CITY OF ALBUQUERQUE

Re: Burger King
7900 Ladera Dr., 87120
30-Day Temporary Certificate of Occupancy- Traffic Certification Only
Transportation Development Final Inspection
Engineer's/Architect's Stamp dated (AA) 2-7-19 (H09D024A)
Certification dated 2-19-19

A1.1

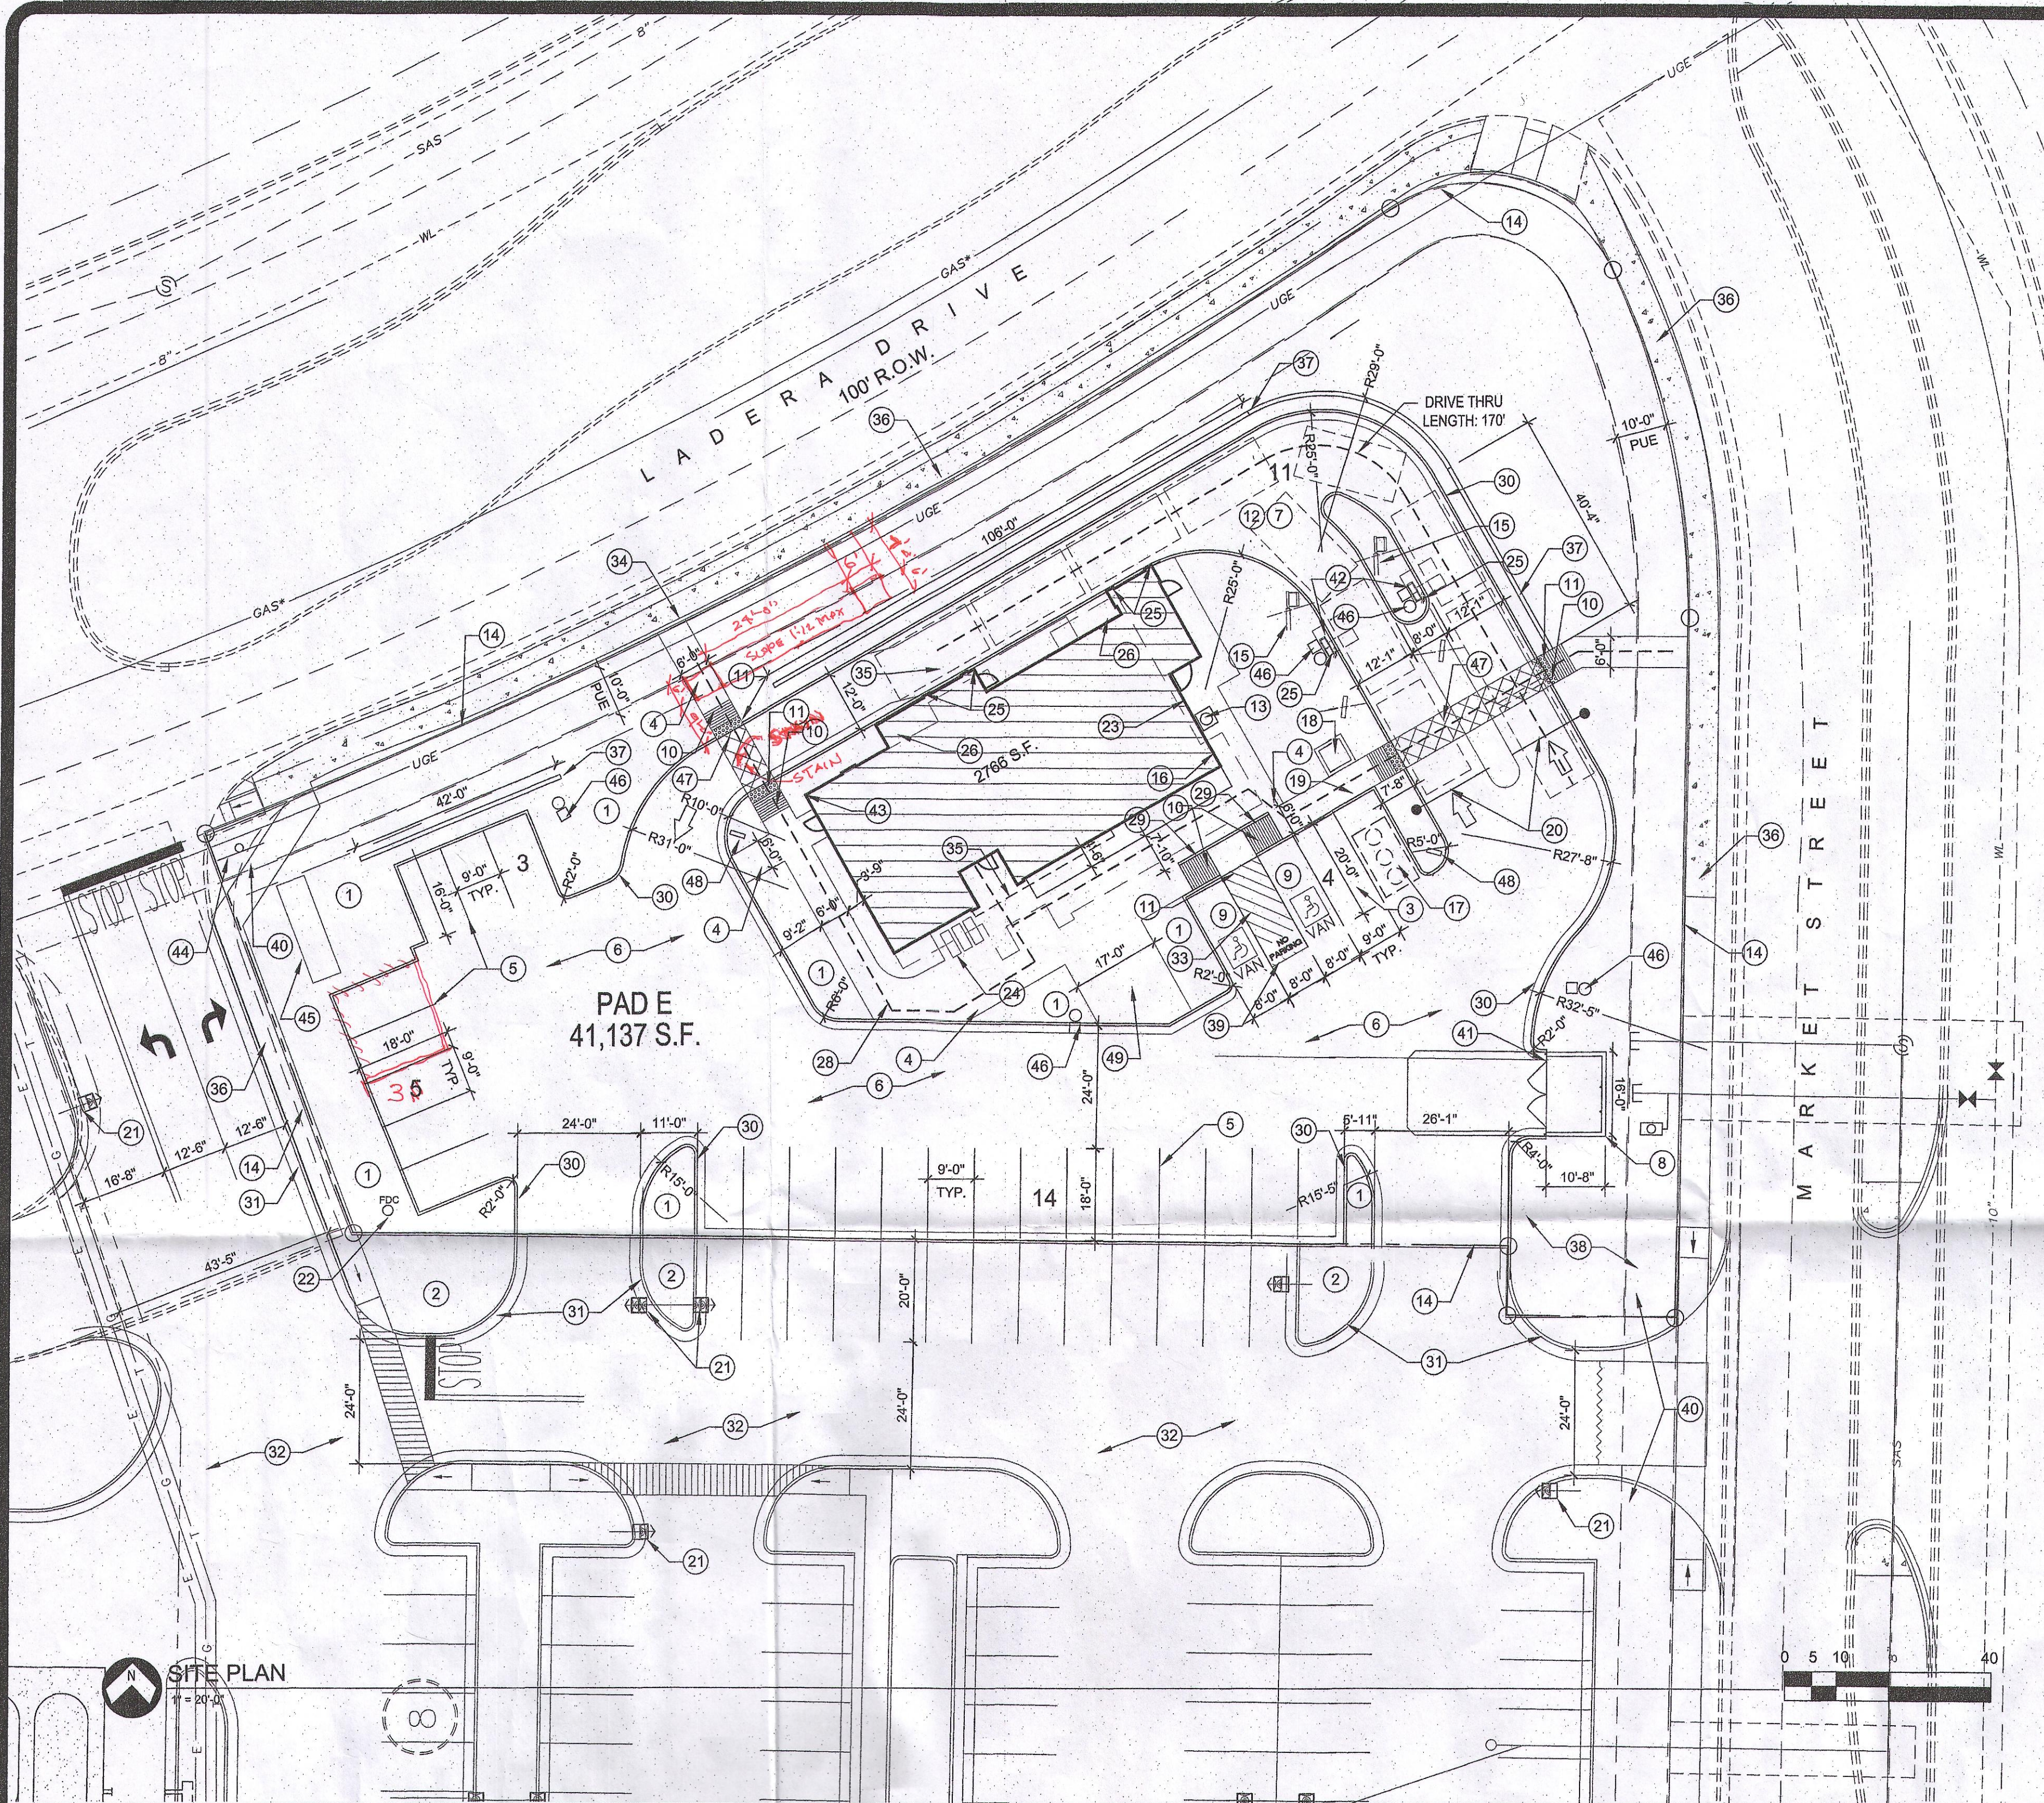
1. Please add bicycle rack.
2. Please stripe the 3 parking stalls facing Ladera and label as compact.
3. Please fix the cracked sidewalk @ corner of Ladera & Market.
4. Please send photos of corrects to PLNDRS@cabq.gov & epgomez@cabq.gov for final CO.
